**Addendum No. 3**

RE: Contract ID C202845

**Craven County (B-4488)**

Bridge Over Slocum Creek And Approaches On SR-1763

LEGEND FOR SECTIONS A-B & C
 CHANNEL EXCAVATION
 PROPOSED ROADWAY EMBANKMENT

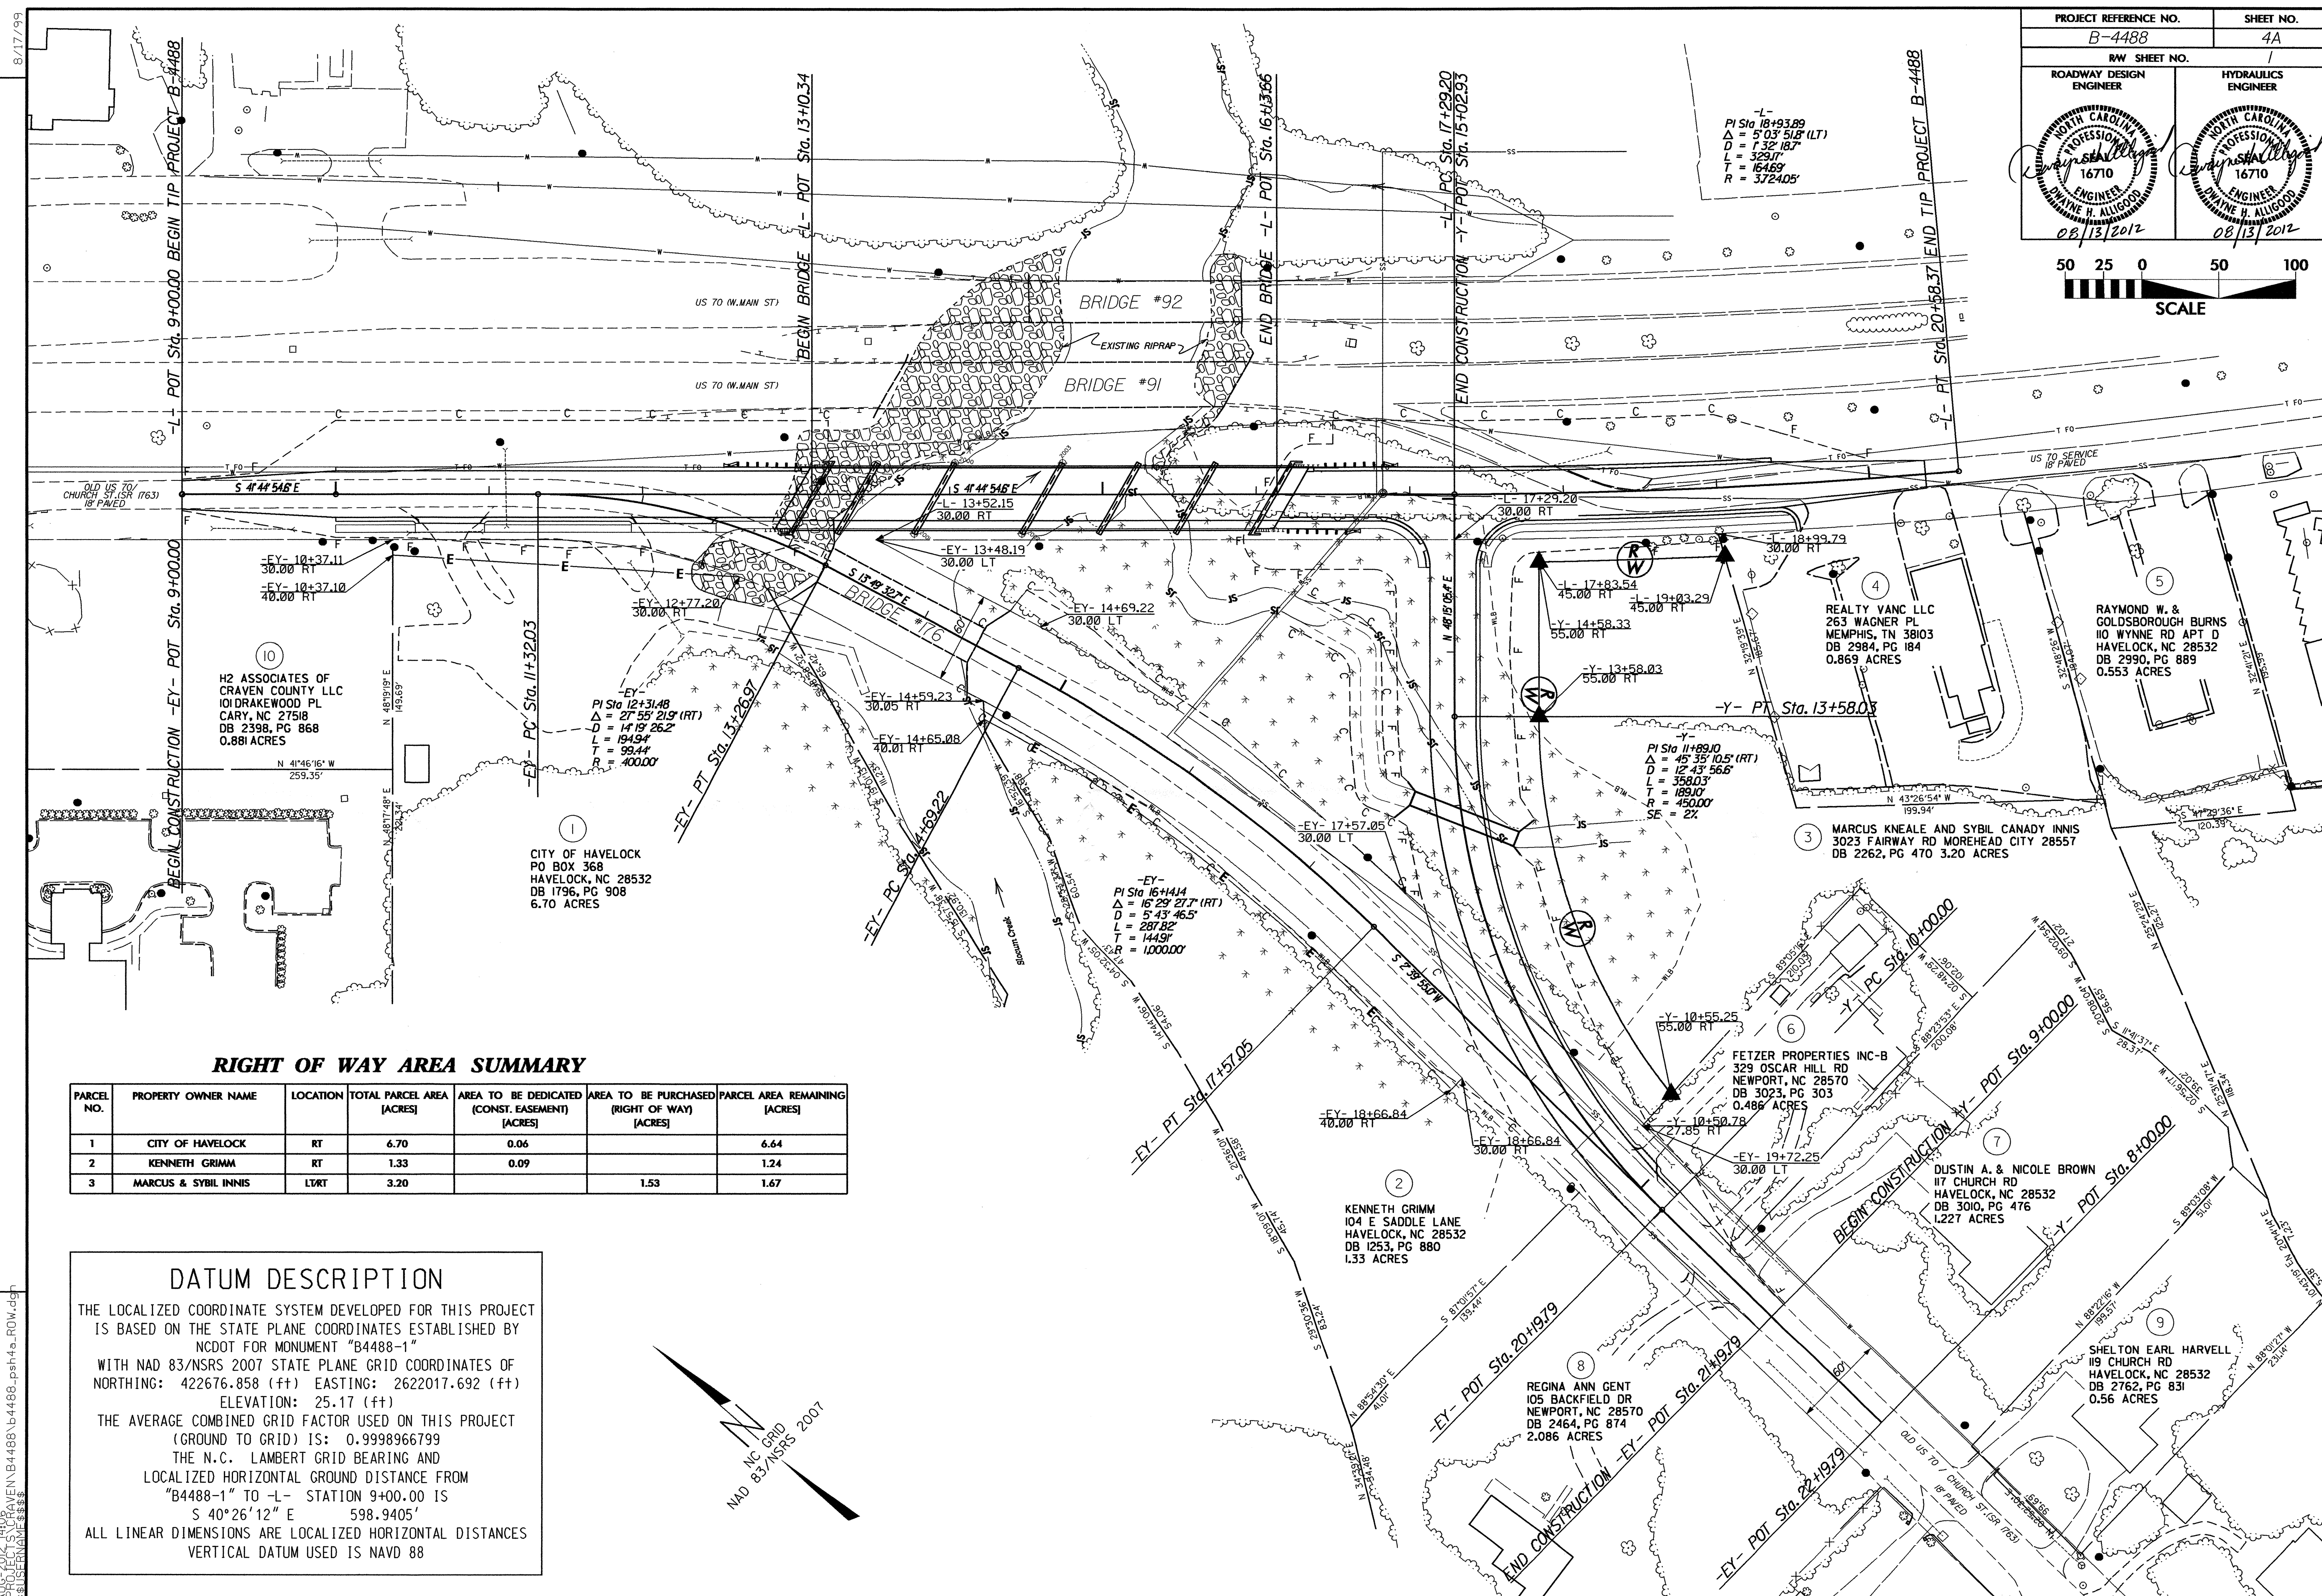
On Sheet No. 4 the "Legend For Sections A, B & C" has been revised. Please void Sheet No. 4 in your plans and staple the revised Sheet No. 4 thereto.
